Our Ref: DOC19/666546
Your Ref: MP 09_0166 MOD 3

Subject: Response to Submissions including an updated BDAR for the Altitude Aspire Residential Subdivision, Terranora (MP09_0166 MOD 3)

Attachment 1: Detailed Biodiversity and Conservation Comments - Updated Response to Submissions Altitude Aspire Residential Subdivision (MP 09_0166 MOD 3)

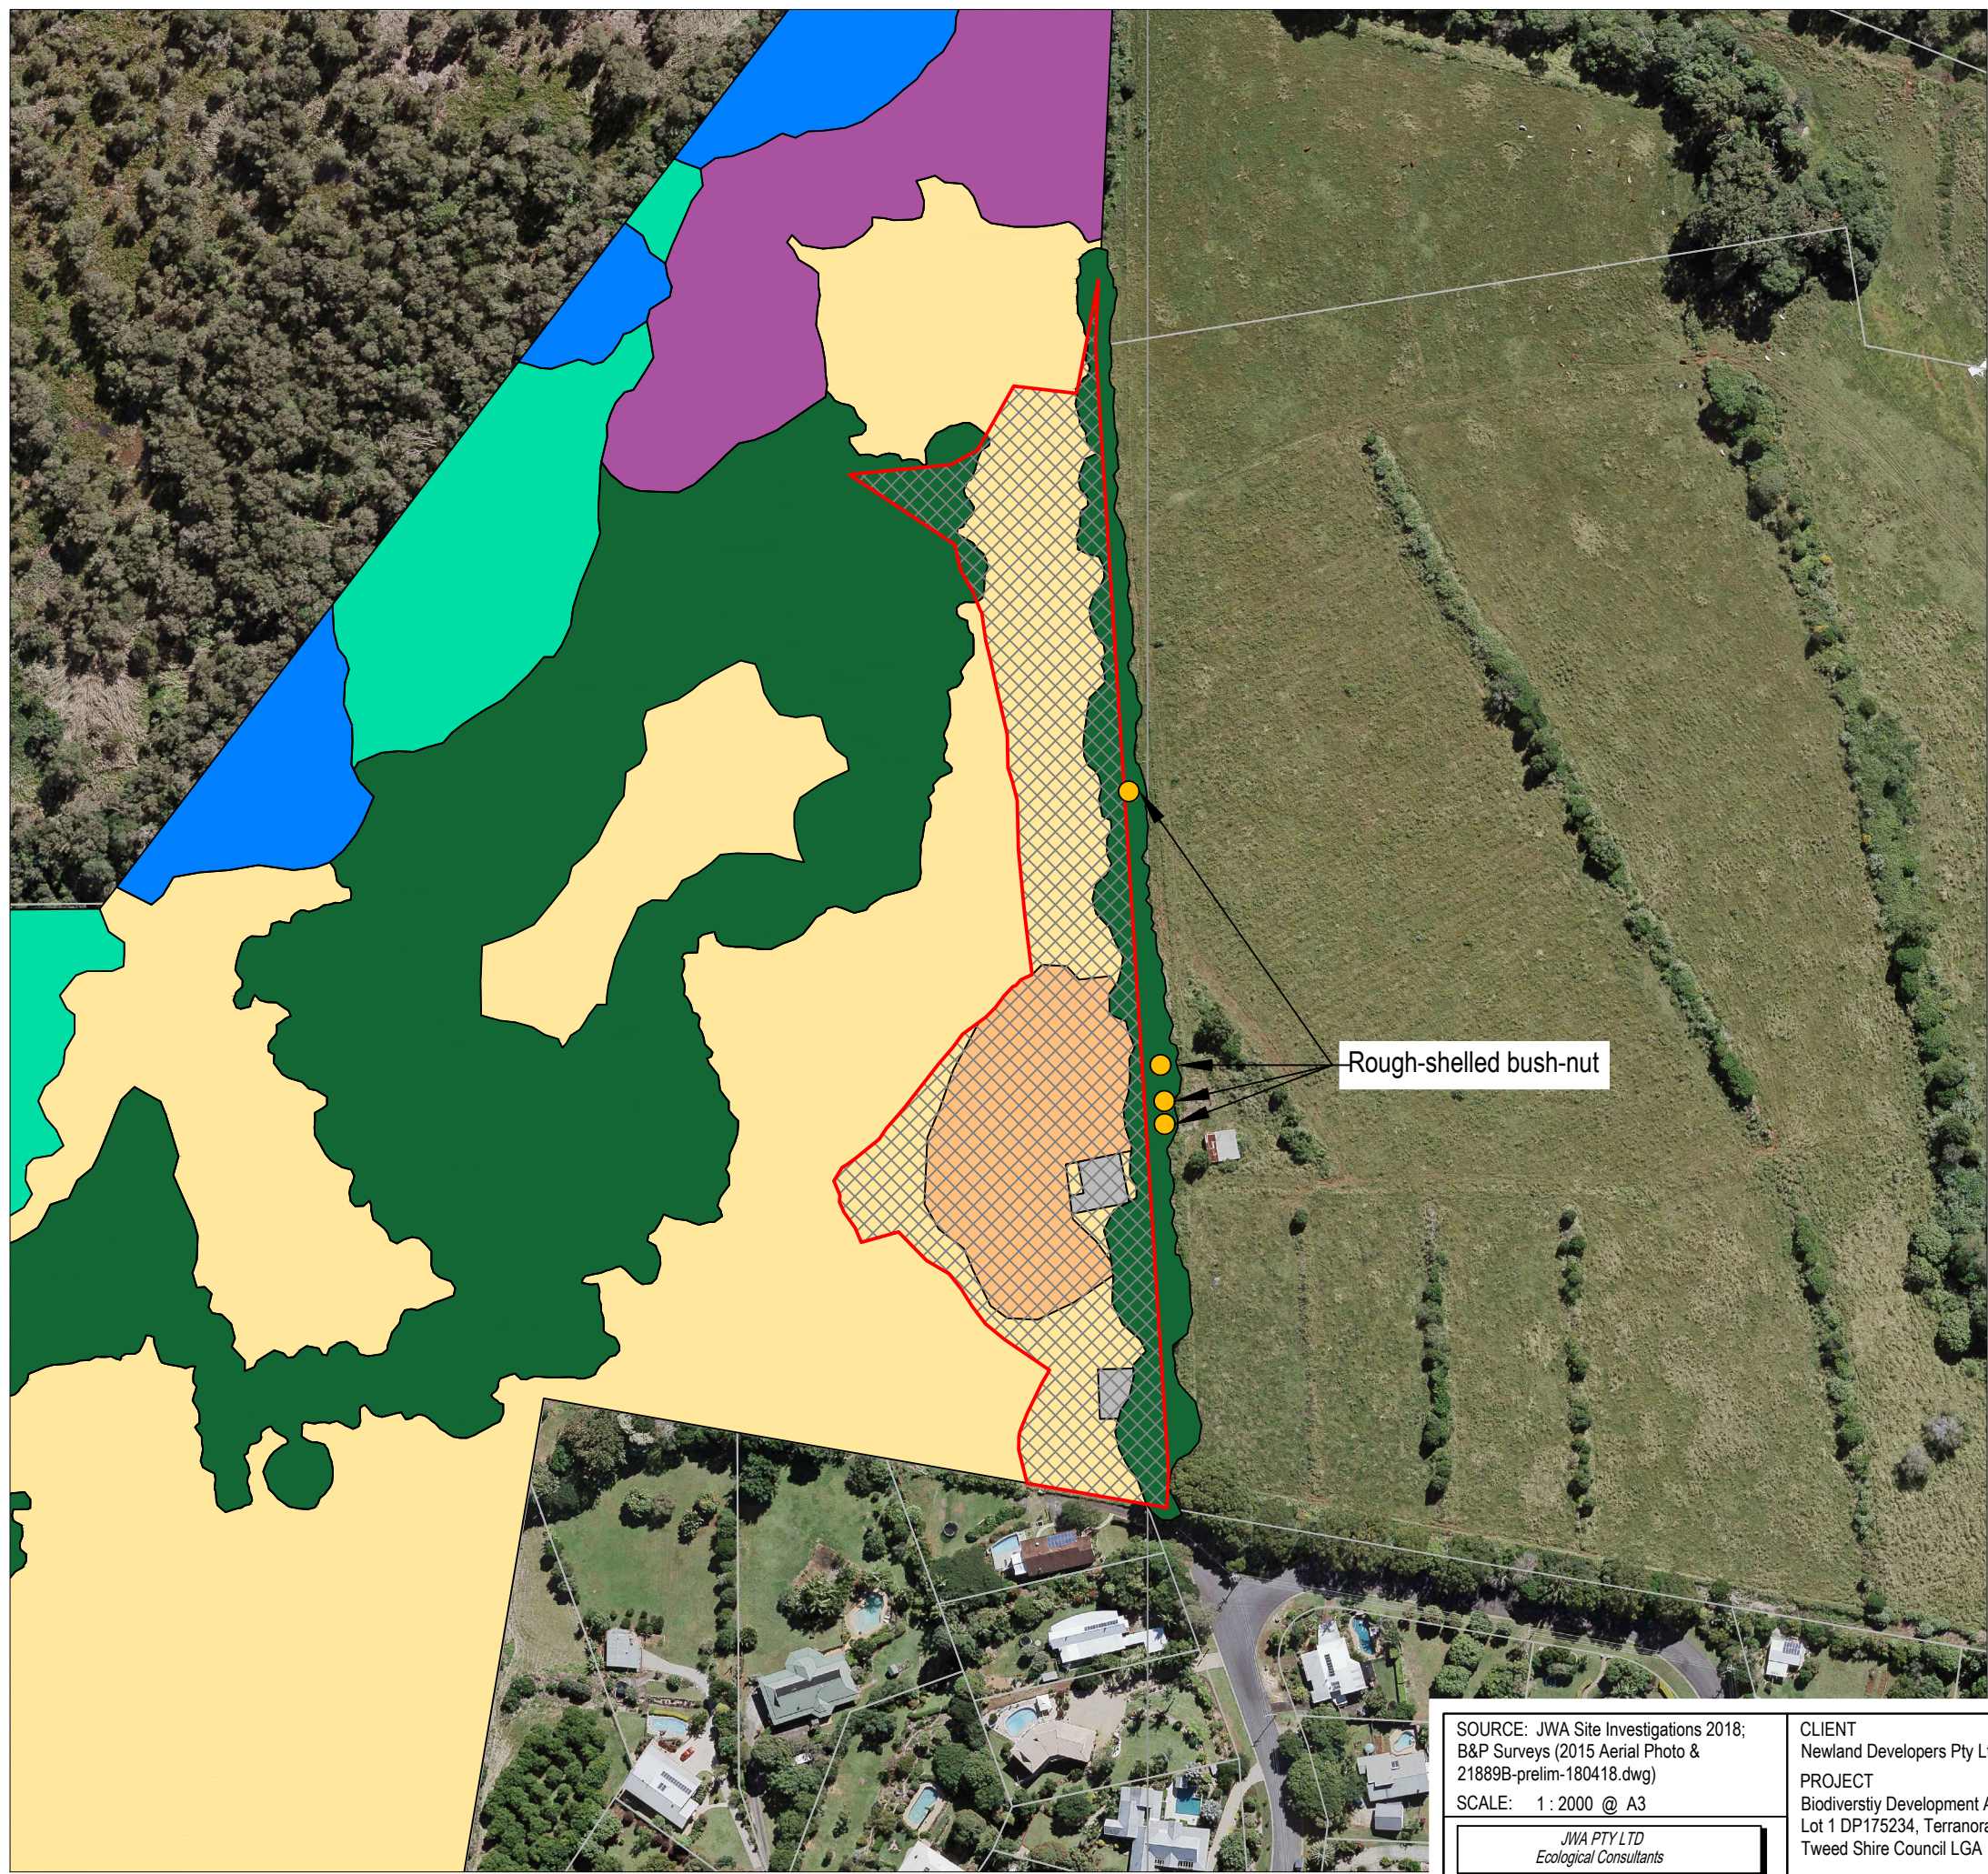
The development involves clearing of vegetation mapped as Vegetation Community 1, occurring both along the eastern boundary and in the north west corner of the development footprint as described in the BDAR (Figure 1). Both areas are described as being a row of predominantly Camphor laurel trees.

The site was inspected by a BCD officer on 13 August 2019 and more than four (4) *Macadamia tetraphylla* were observed ranging in size in Vegetation Community 1 on the eastern boundary of the site as identified in the revised BDAR. *Macadamia integrifolia* plants were also observed, but this site inspection was brief, and it was not possible to undertake an adequate survey in the time available.

Given the different results from past surveys for *M. tetraphylla* and the possibility that the vegetation community on the eastern boundary may also contain *M. integrifolia/tetraphylla* hybrids a further study should be undertaken to determine the precise numbers of each Macadamia species to be impacted by the proposal and that voucher specimens be sent to the NSW Herbarium for a DNA analysis to confirm whether they are *M. tetraphylla*, *M. integrifolia* (as a wild population) or a hybrid. The results of this further survey should be provided to the BCD for further comment.
